Please ask for: Mrs D Johnson
Email: daun.johnson@arun.gov.uk
Telephone: 01903 737762
Our Ref: BR/73/22/PL
Your Ref:
Date: 19th April 2022

Application for Planning Permission

Development: Installation of bicycle and refuse/recycling store within rear garden, install window at end of eastern side retain, replace windows to west and east side elevations and install glazed French doors and windows to southern rear elevation. This application is in CIL Zone 4 (Zero Rated) as other development.

Location: 83 Aldwick Road Bognor Regis PO21 2NW

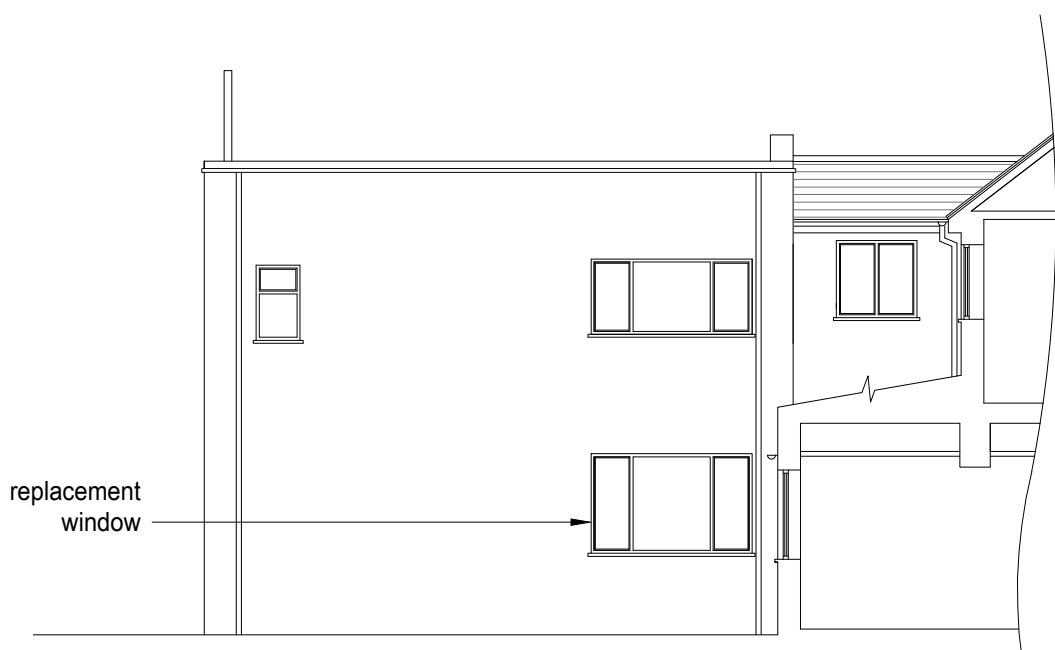
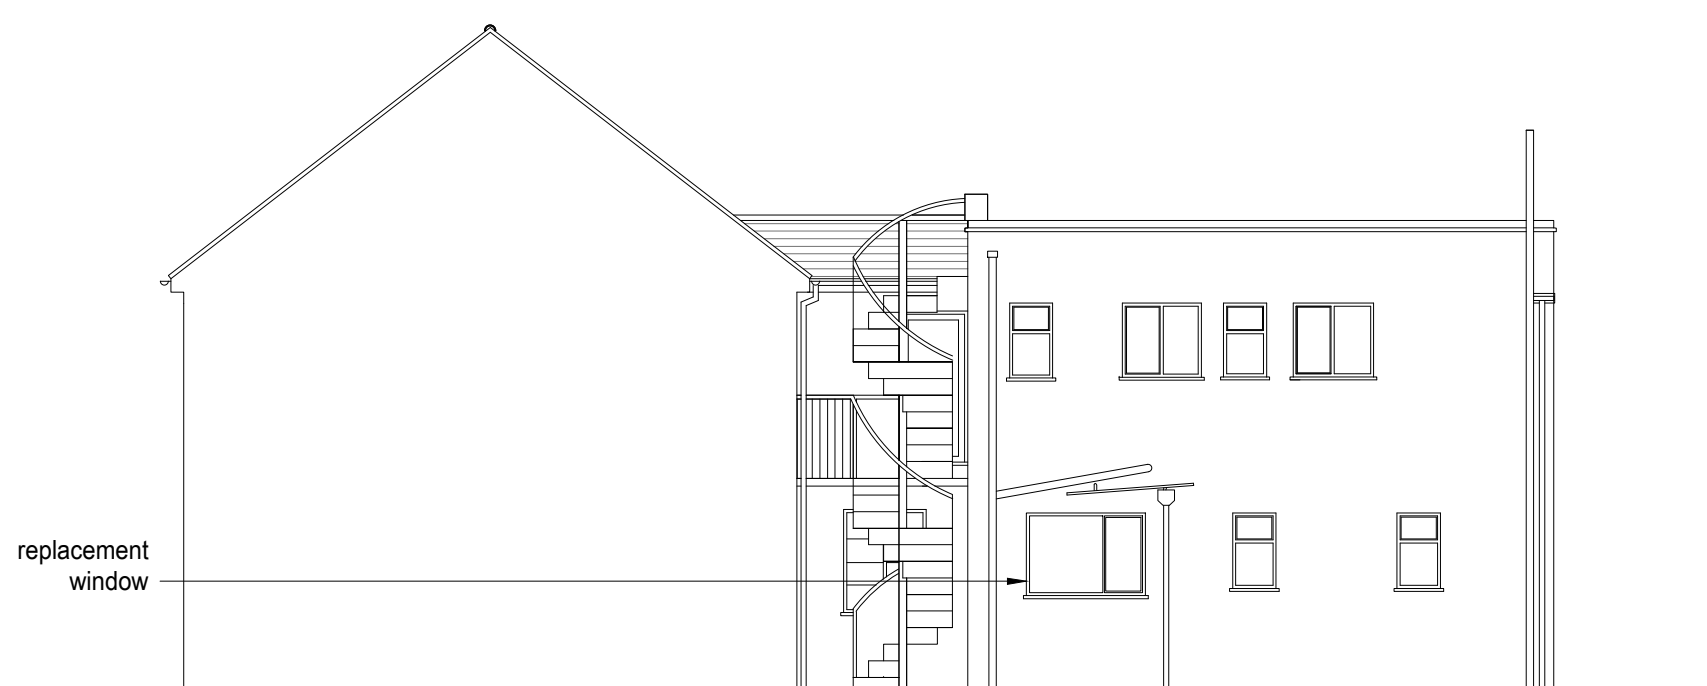
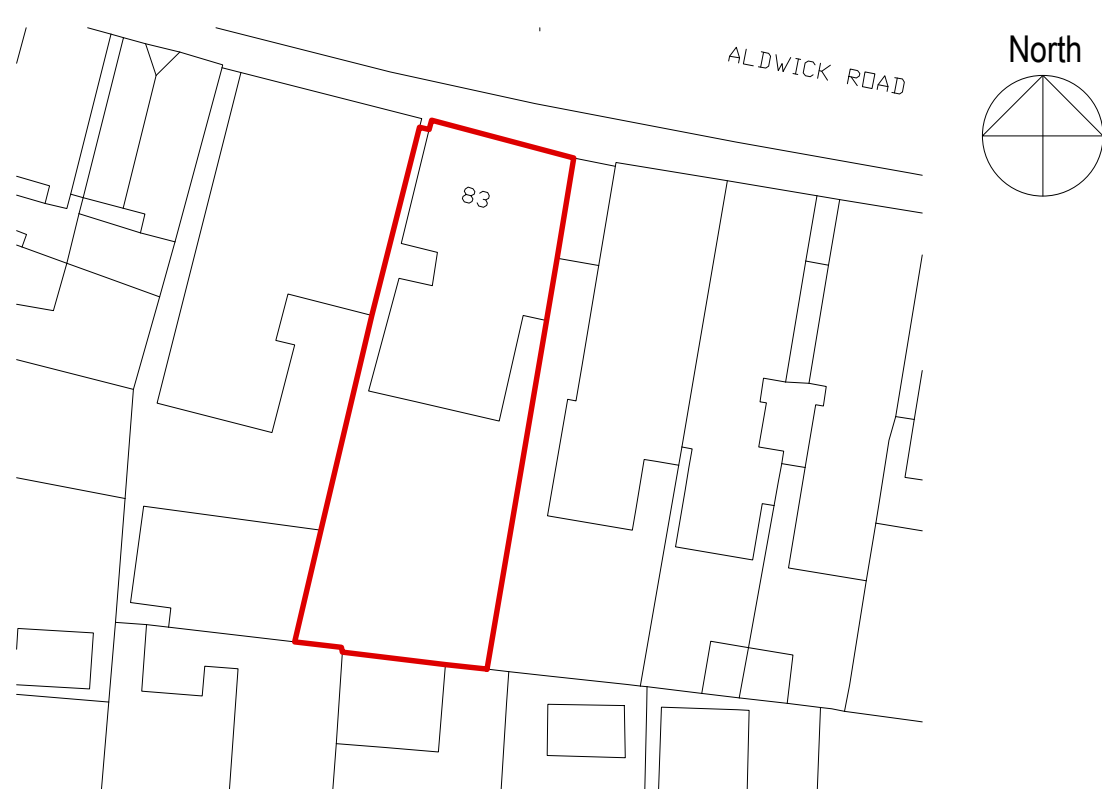
The legend for Plan states Proposed ground floor and second floor plan, however, there is not a proposed second floor plan on the plan. Please clarify.

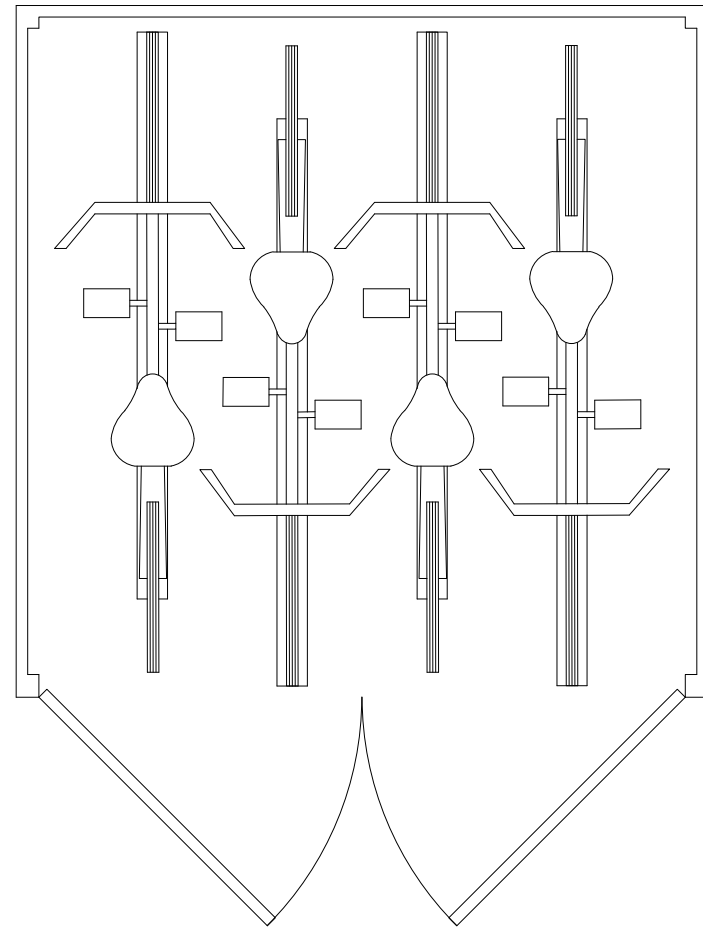
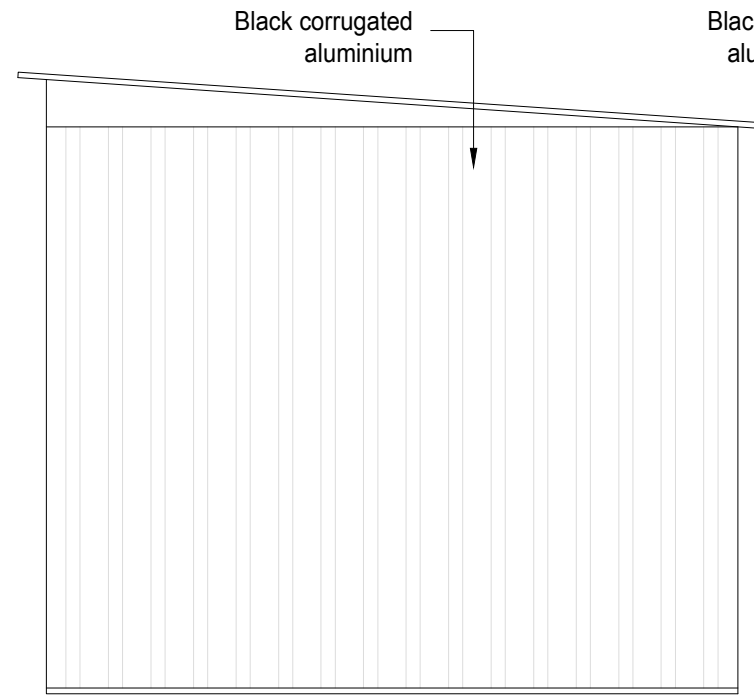
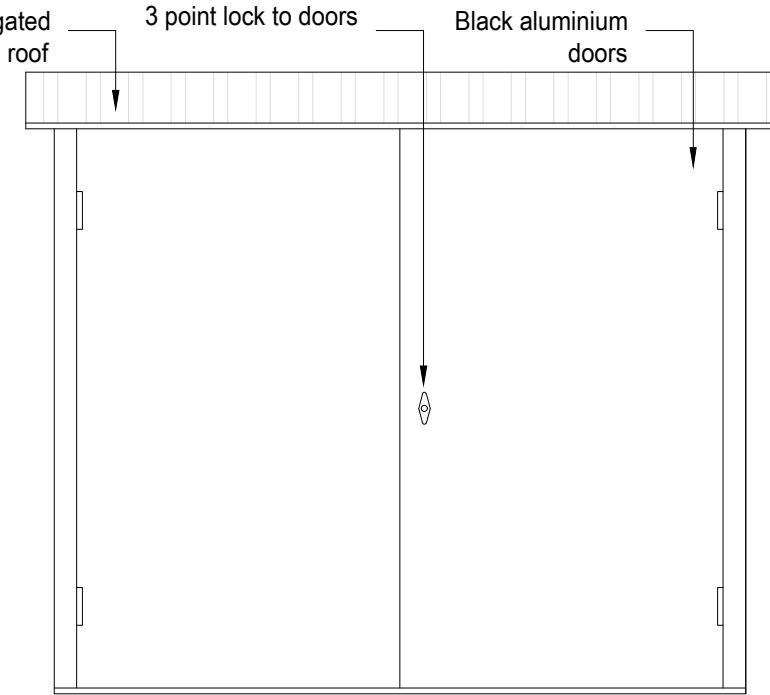
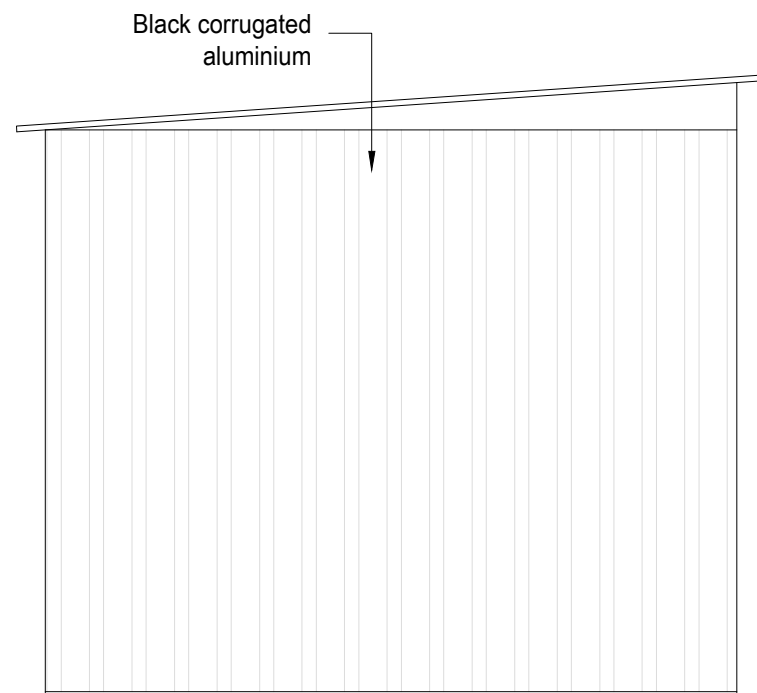
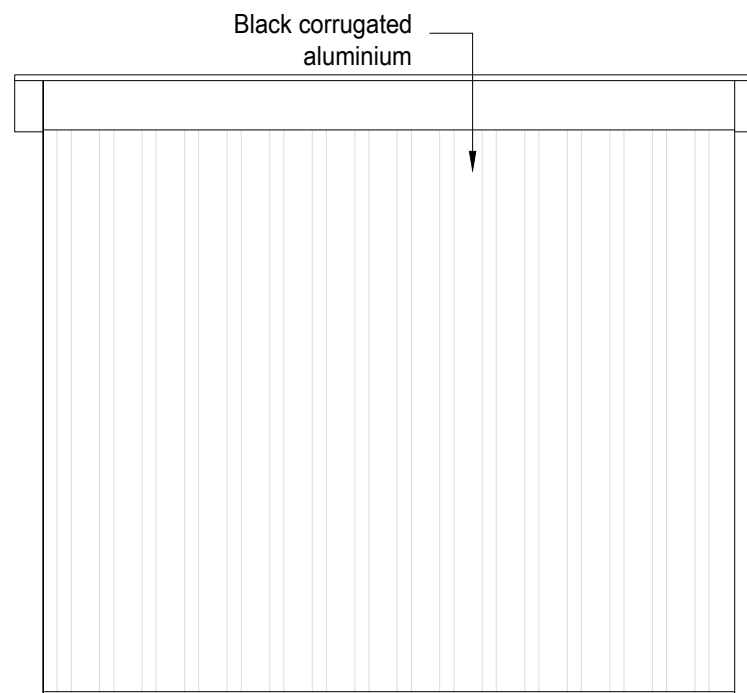
Please provide proposed elevations for the bicycle and refuse/recycling store.
